<b>Application Ref:</b>	3/2025/1001	 Ribble Valley Borough Council <a href="http://www.ribblevalley.gov.uk">www.ribblevalley.gov.uk</a>
<b>Date Inspected:</b>	N/A	
<b>Officer:</b>	LH	
<b>DELEGATED ITEM FILE REPORT:</b>		<b>APPROVAL</b>

<b>Application Description:</b>	Non material amendment to application 3/2022/0966 involving increase in height of southern boundary fence line (20cm) and provision as acoustic fence, following updated acoustic information
<b>Site Address/Location:</b>	Crow Trees Farm, Crow Trees Brow, Chatburn, BB7 4AA.

CLIENT	Pringle Homes				
PROJECT	Proposed Residential Development at Crow Trees Farm, Crow Trees Brow, Chatburn, Clitheroe, Lancashire, BB7 4AA				
DRAWING	Proposed Boundary Treatment Details				
DRAWN	JAL	DATE	23/07/25	NUMBER	21/139/BT01
SCALE	Varies	SHEET	A1	REVISION	C

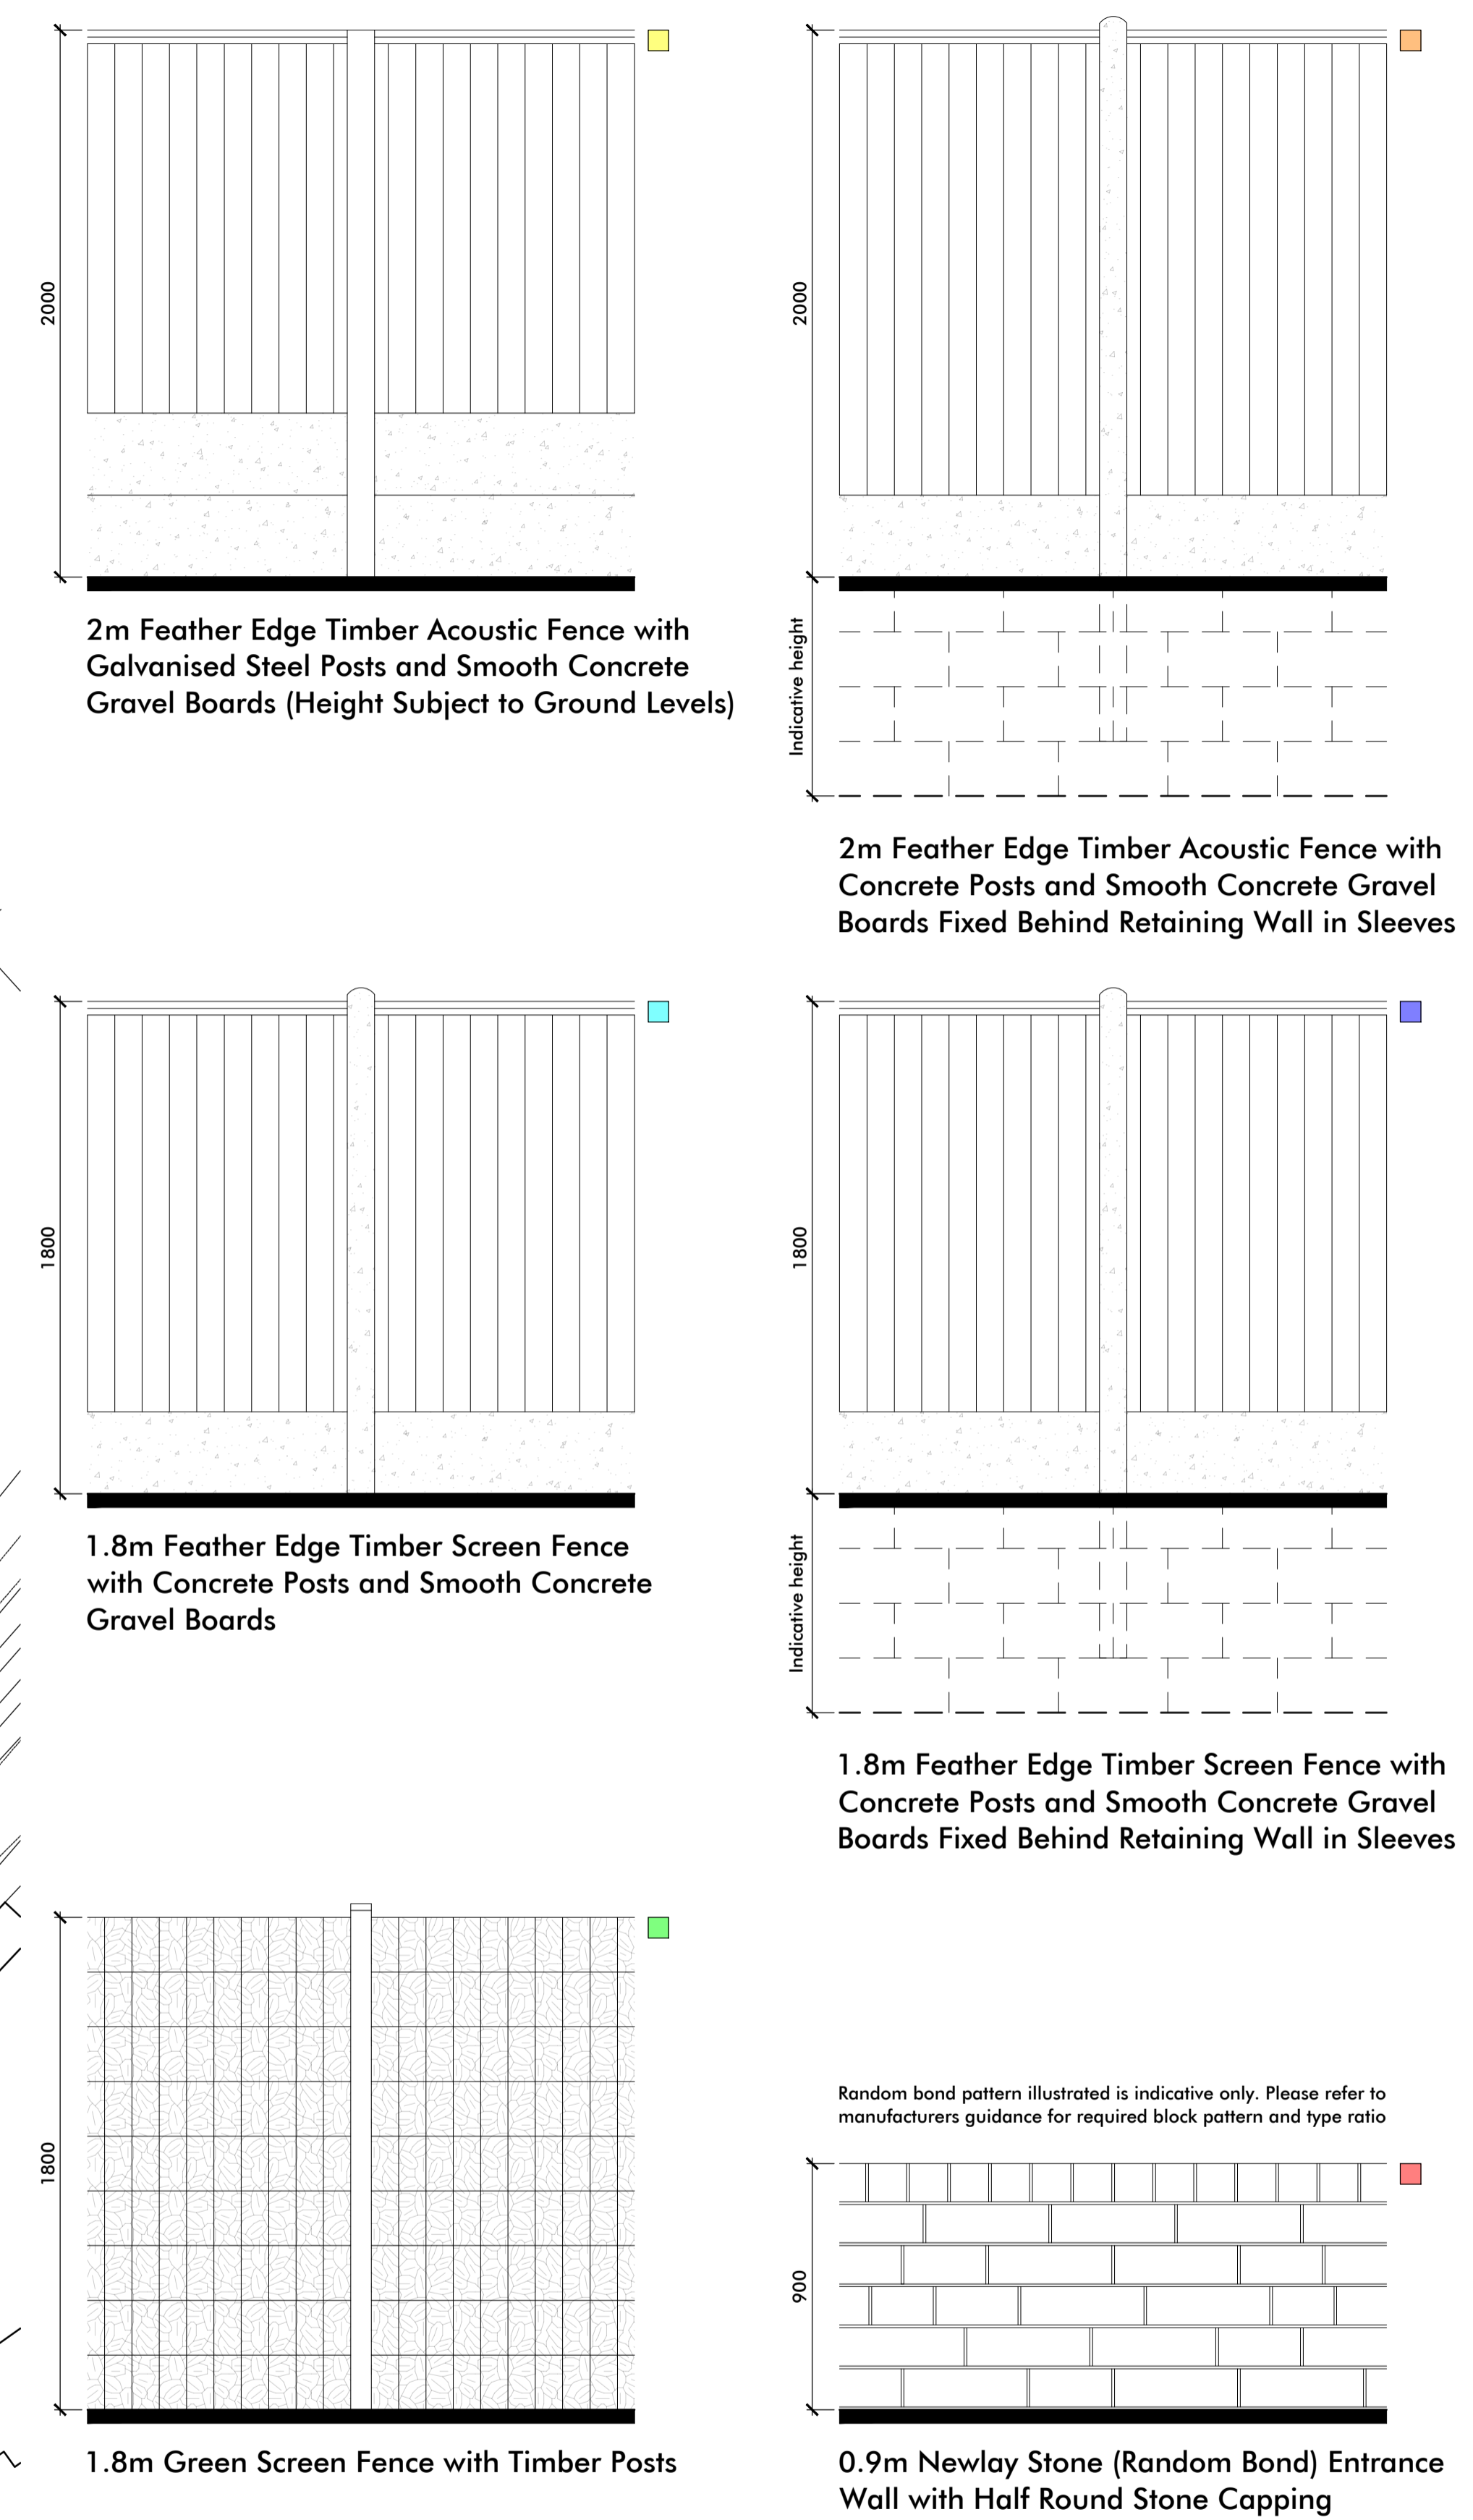
<b>ASSESSMENT OF PROPOSED DEVELOPMENT:</b>
<b>Nature of Non-Material Amendment:</b>
<p>Consent is sought for a non-material amendment to application 3/2022/0966 which granted consent for the erection of 37 residential units with access, parking and landscaping, conversion and extension of a former dairy and refurbishment of a listed farmhouse building. Minor revisions to this consent with respect to electric vehicle charging points, cycle storage provision, house type alterations and air source heat pump locations were subsequently approved under non-material amendment application 3/2025/0001.</p> <p>The purpose of the application is to seek the Council’s opinion as to whether the changes to the previously approved development are sufficiently material in their nature and in the context of the approved development so as to require a new planning permission. Non-material amendment applications are not an application for planning permission. They do not result in the issuing of a new planning permission and relate only to the amendments sought.</p> <p>In this instance, the amendment sought relates to alterations to the previously approved boundary treatments along the southern boundary of the site and part of the side return along the eastern boundary from a 1.8m high boarded fence to a 2m high acoustic fence. Amended plans received confirm the previously approved boundary hedge and trees will be retained alongside this fencing. Additionally the plans indicate a 2m high acoustic fence along the north (side) and eastern (rear) boundary of plot 1. The</p>

approved boundary treatment plan (approved under condition 27) shows a 2m high fence along the side boundary and a 1.8m high close boarded fence along the rear. The plans demonstrate this will sit above a retaining wall however this has previously been approved as part of the levels details provided / approved for condition 22.

The amendments are being sought because the acoustic report demonstrates that this acoustic fencing will reduce the number of plots that are required to have powered ventilation.

Whilst third party concerns are noted, the fence height and level changes described generally reflect the previously approved details. Should this not be the case then this would be a matter for the Council's Enforcement Team to investigate if deemed necessary.

The proposed changes do not represent a material change to previously approved boundary treatment details, in terms of impact on visual or residential amenity.
